Andrew Lewis
Cherwell District Council
Bodicote House
Bodicote
BANBURY
OX15 4AA

Our Ref: SE/CL/2015/39037/S

App Ref: 15/00153/REM
Site: Heyford Park, Camp Road, Upper Heyford, Bicester, OX25 5HD
Proposal: "Reserved Matters to Outline application 10/01642/OUT - Village green including sports provision."

Village Green Landscape Proposals
Scale 1:200

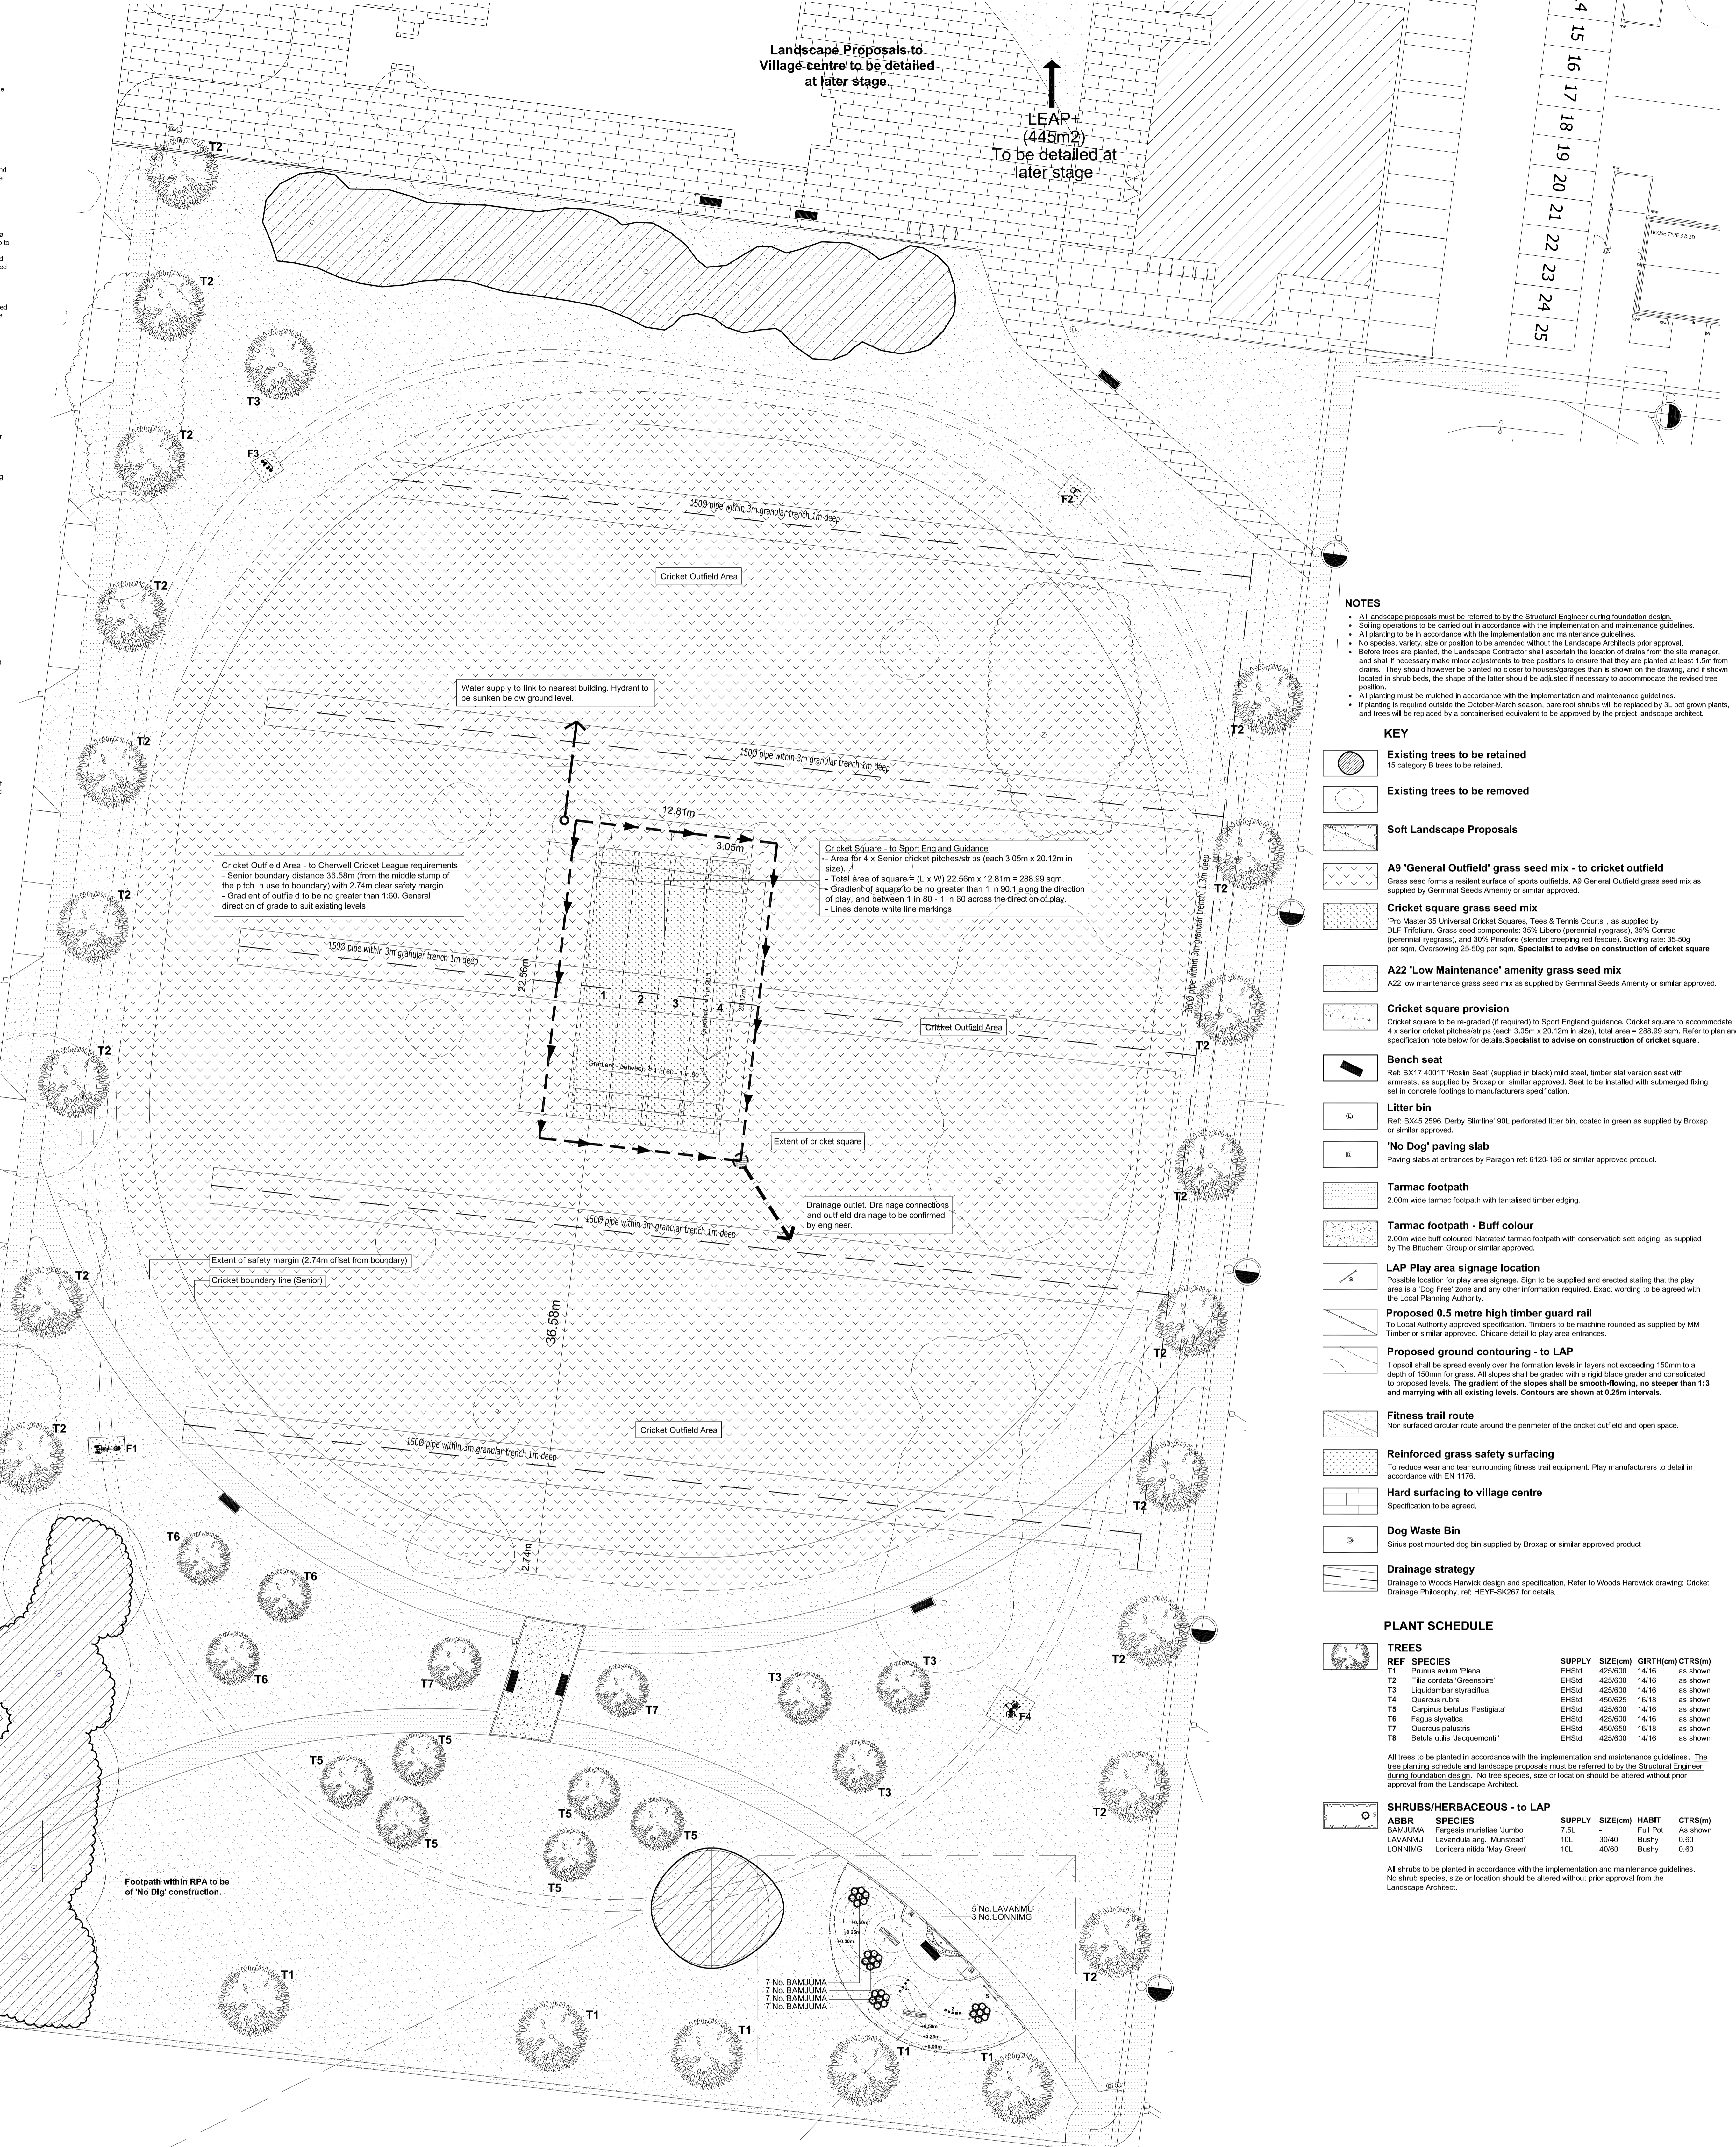
While the dimensions of the proposed cricket square accord with design guidance published by Sport England and the requirements of the England and Wales Cricket Board (ECB), the distance to the boundary of the outfield (36.58m) is too short. The minimum required distance is 45.72m (please see <http://www.sportengland.org/media/30820/Natural-Turf-Senior-Cricket-8-Pitch.pdf>). The proposed facility will not be fit for purpose or sustainable in the longer term.

The proposed development will give rise to a conflict between the use of the village green for cricket and the neighbouring uses, particularly housing. Cricket balls commonly travel in excess of 70m at all levels of ability. Therefore, a cricket ball landing on adjoining property is likely to be a relatively common occurrence in this location. The cricket club would be liable for damage to property and personal injury.

In the current application, no mitigation measures have been proposed to address the risk of cricket balls leaving the site.

The reserved matters application has also been submitted without any ancillary provision in the form of a pavilion with changing accommodation. The absence of such provision adds to the view that the proposed facility will not be fit for purpose.

The proposed layout of footpaths, seating, play area and planting, on the southern part of the site, will prejudice the use of the land for other outdoor sport.
